DRB Application No.: 07DRB-00333 (P&F)
Project Name: EASTERN ADDITION
Agent: Surveys Southwest

6. **Project # 1005302**
07DRB-00333 Minor-Prelim&Final Plat
Approval

RE: Lot 7, Block 26, Eastern Addition/ p & f plat

**PLAT OF  
LOTS 7-A & 7-B, BLOCK 26  
EASTERN ADDITION  
PROJECTED SECTION 29, T. 10 N., R. 3 E., N.M.P.M.  
TOWN OF ALBUQUERQUE GRANT  
CITY OF ALBUQUERQUE  
BERNALILLO COUNTY, NEW MEXICO  
MARCH 2007  
SHEET 1 OF 2**

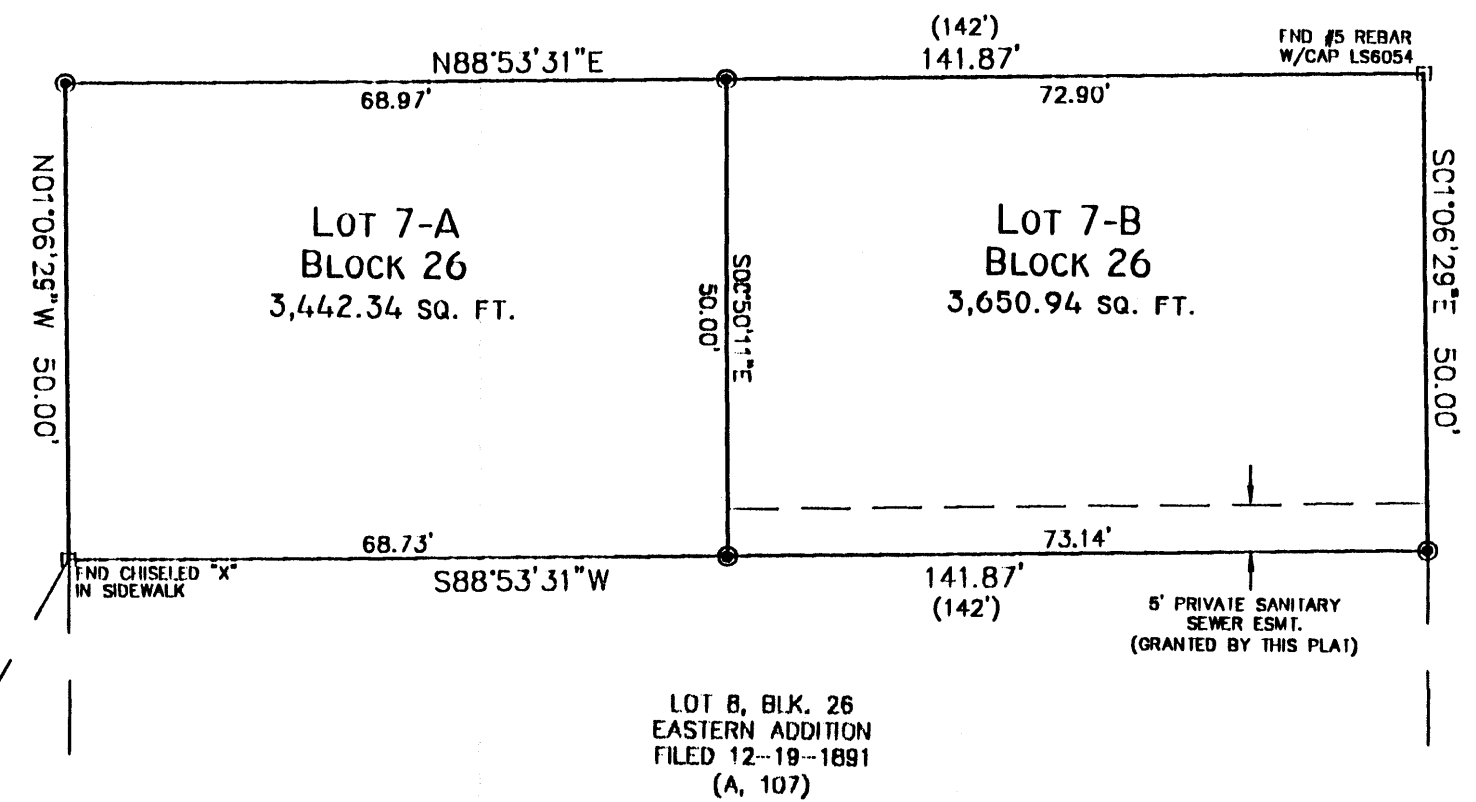
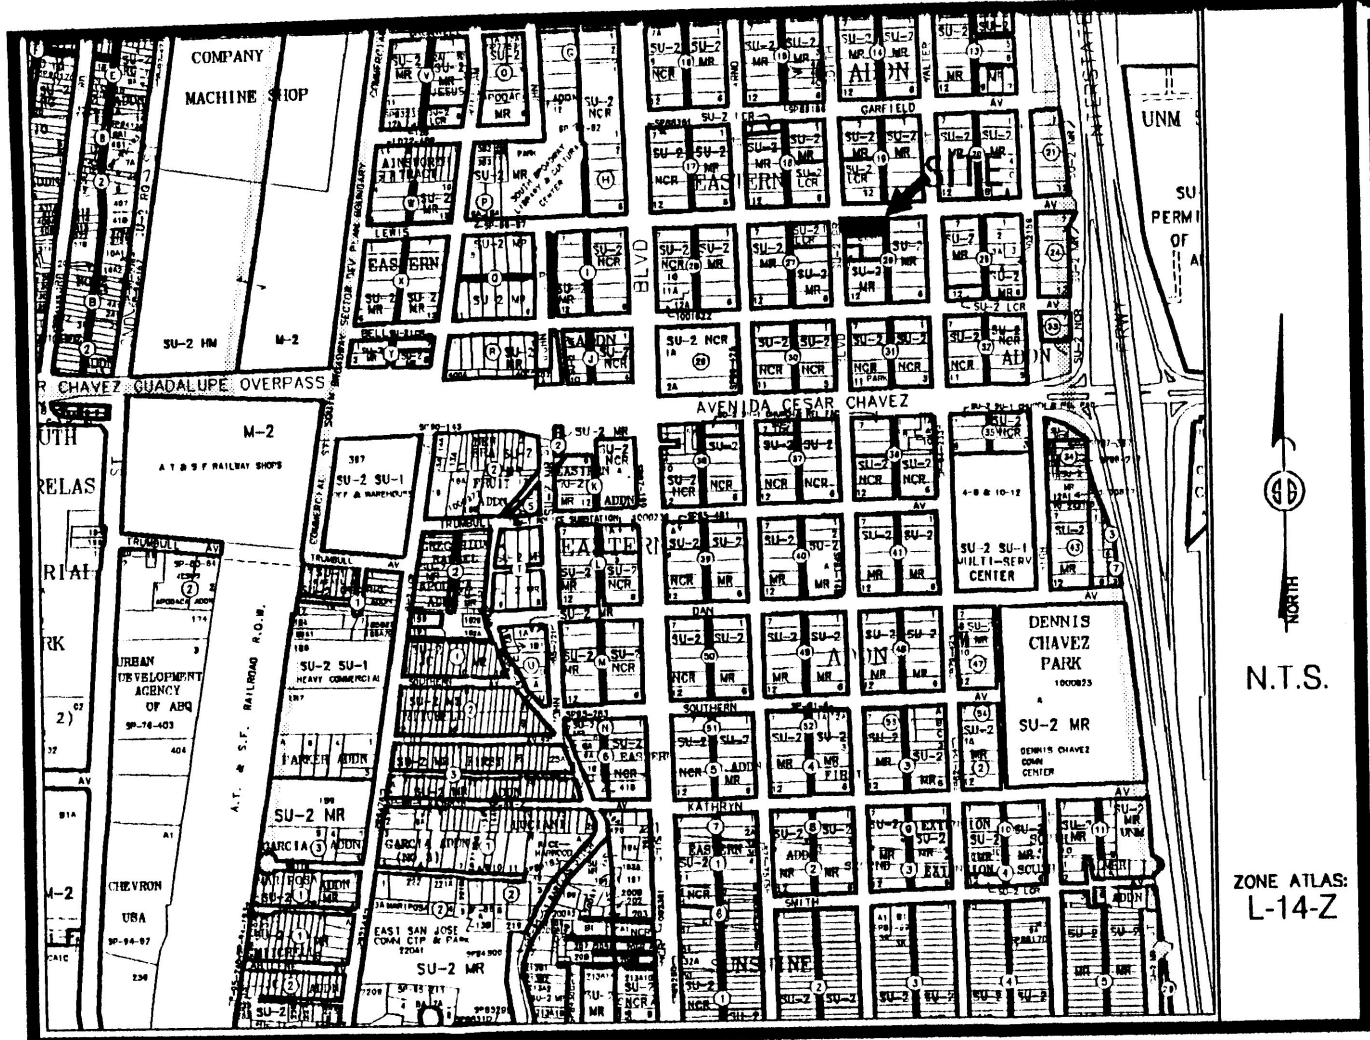
UTILITIES: Need Private Sanitary Sewer service line easement and appropriate language

The APS language on the plat doesn't apply for existing residential uses. Please remove the language.
